ASSESSMENT REPORT

Student Accommodation Development 60-78 Regent Street, Redfern SSD 6724 MOD 2

60-78 Regent St  
Redfern  
East Elevation

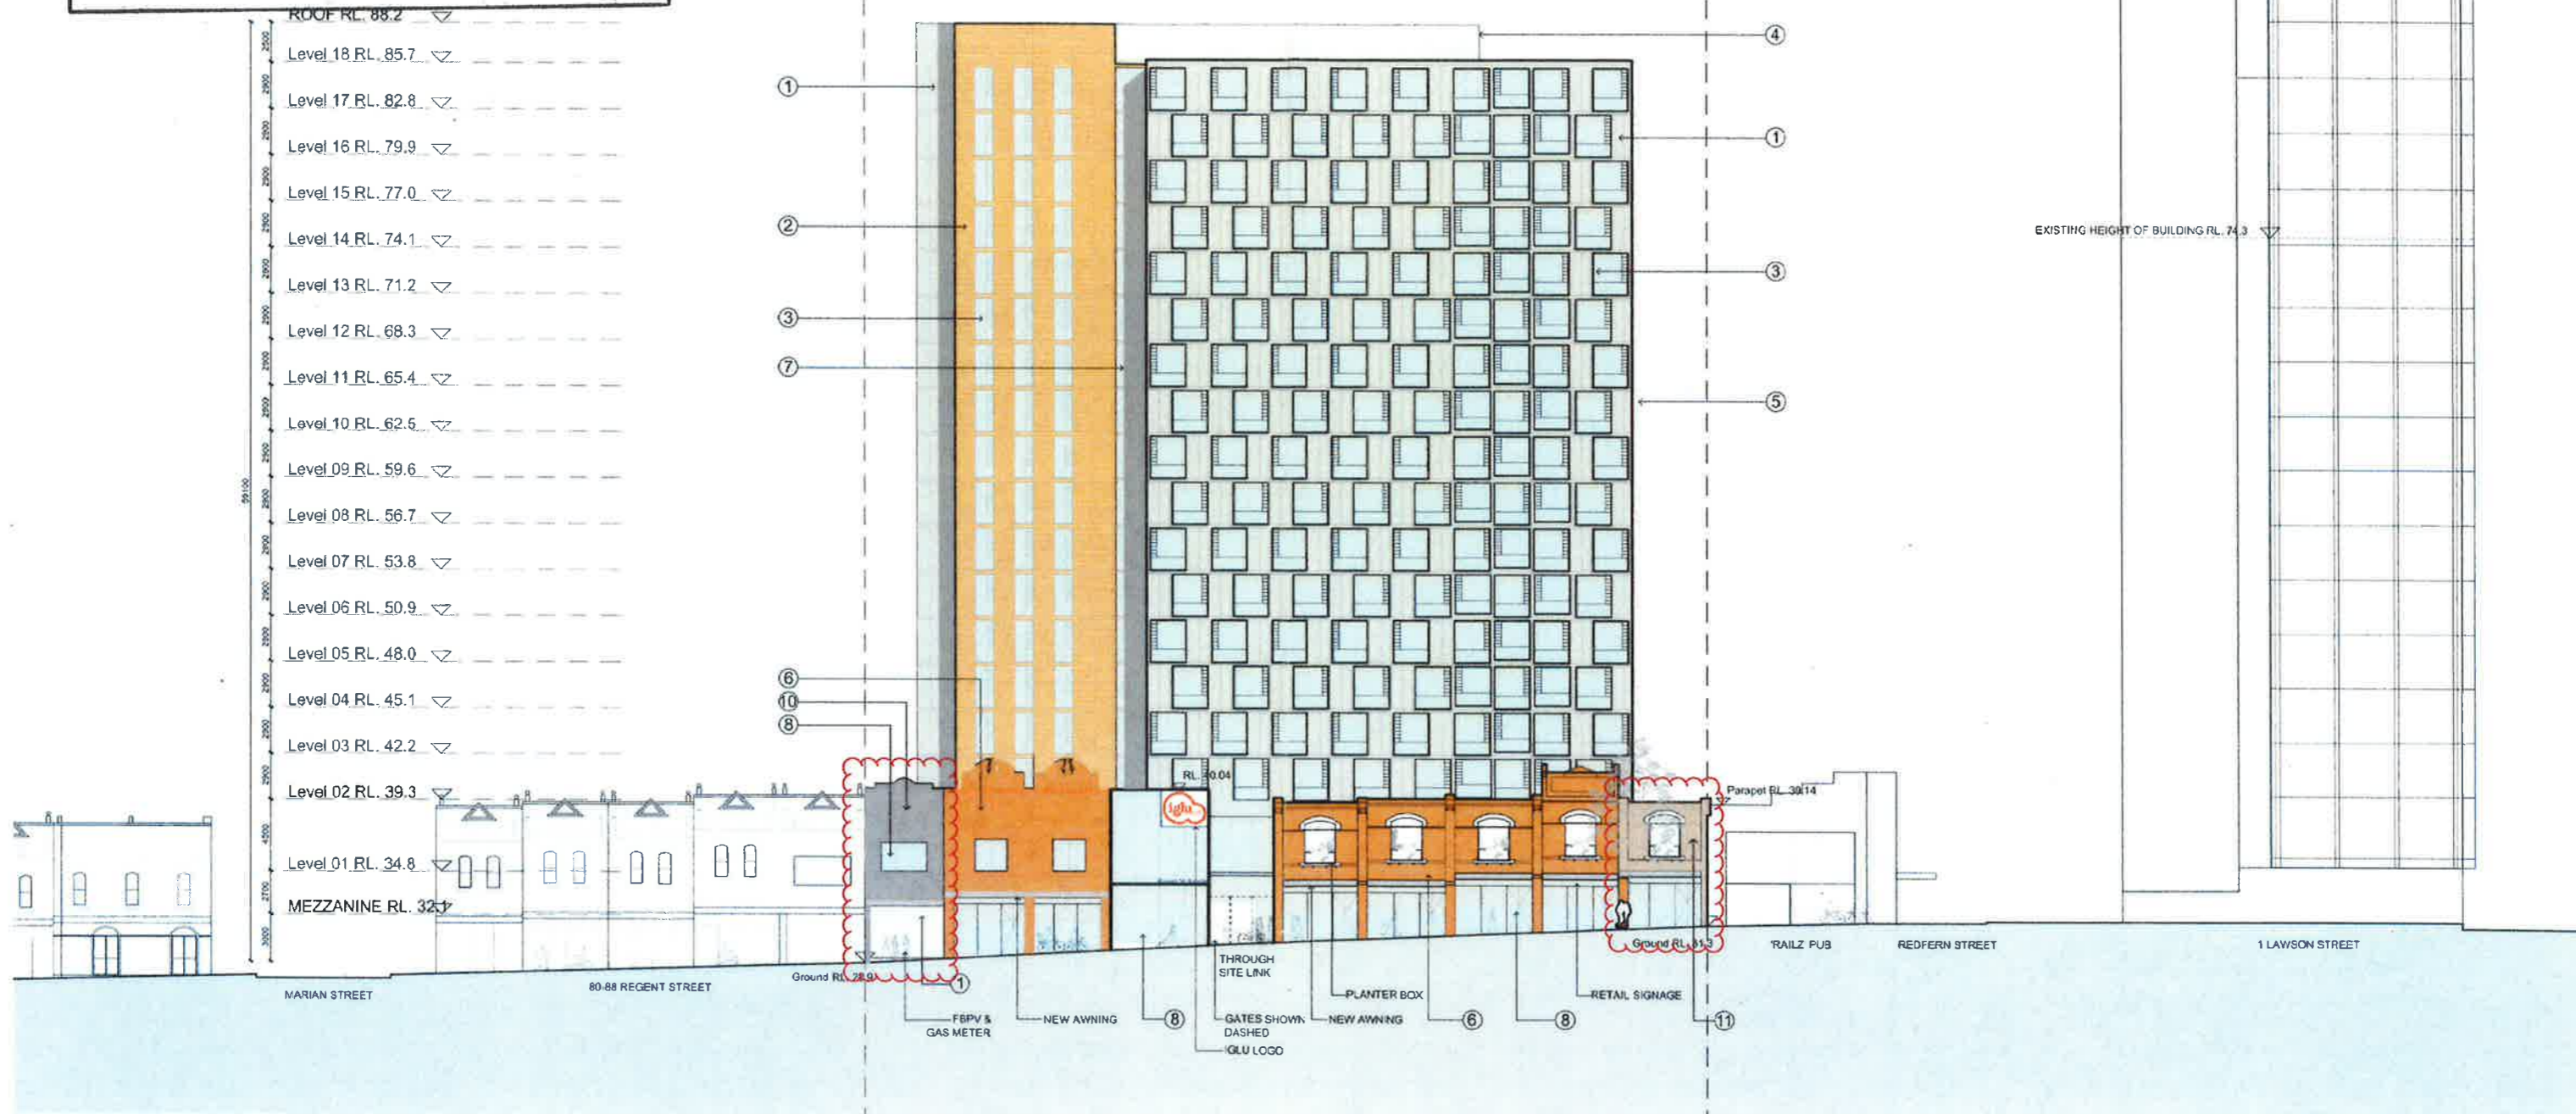
On 14 July 2017, the Applicant lodged an application (SSD 6724 MOD 2) seeking to modify the approved façade treatment of two shopfronts along the eastern elevation (Regent Street). Currently, the consent requires the rendered finish on the two shopfronts to be removed to restore the original face brick (Figure 4). However, the modification application seeks to retain the rendered finish and re-paint the façade in neutral tones as removal of the current rendered façade would damage the brickwork (Figure 5).

The proposed modification seeks approval to modify the finishes of two shop front façades. The consent currently requires the restoration of the two shop fronts to reveal the existing face brick. As per the letter prepared by Richard Crookes Constructions (**Appendix B**), it has been identified that the current render and bagging on the façade would cause some damage to the brickwork underneath when removed. Therefore, restoring the face brick would likely result in a low-quality finish.

- the existing facades do not have any recognised heritage values in that they are not heritage items or within a conservation area
- the proposed paint work finish would result in a higher quality presentation of the façade (rather than a damaged façade)

- the proposed façade treatment would be consistent with the range of façade treatments on surrounding buildings
- no physical change to the façade is proposed
- no adverse impacts are associated with the proposed change in finishes.

The Department's assessment therefore concludes the proposal is acceptable and would not result in any adverse visual or amenity impacts.
